From: Laura Gibbons <Laura.Gibbons@arun.gov.uk>
Sent: 20 September 2019 12:14
To: Planning.Responses <Planning.Responses@arun.gov.uk>
Cc: Maria Tomalova <Maria.Tomalova@arun.gov.uk>
Subject: RE: Planning Consultation on BN/70/19/DOC

Engineers Comments Regarding Condition 15

APPLICATION NO: BN/70/19/DOC

Site Address: Former Brooks Nursery Eastergate PO22 0ED

Drawing No. 4482:506
Rev D

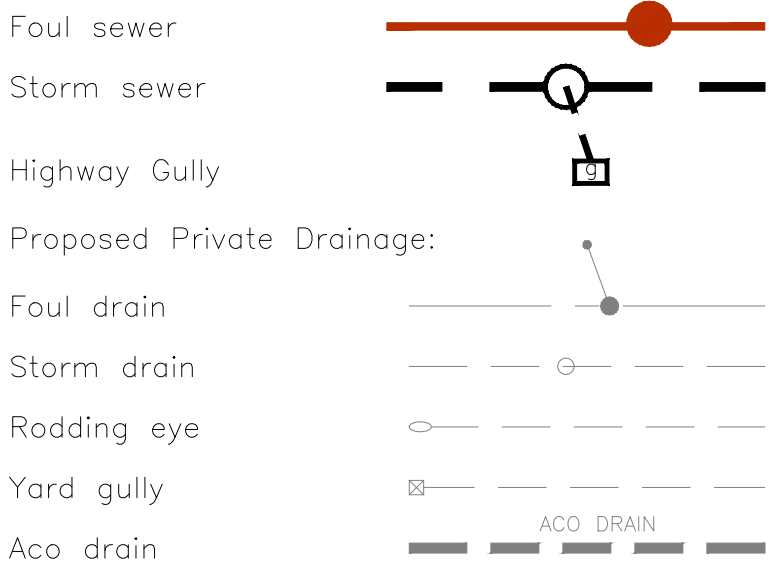
We have been involved with early discussions regarding this proposal and broadly support it as it will remove the current discharge to the SuDS from a package treatment plant. We would like to see additional notes added to the drawing to confirm that the existing foul pipe will be appropriately abandoned.

The proposals include the infilling of the swale. Please can it be confirmed if the swale formed part of the required storage volume for surface water drainage?

The proposals show the new proposed rising main crossing the existing surface water network, it must be ensured that the foul main does not clash with the surface water pipe entering the SuDS feature.
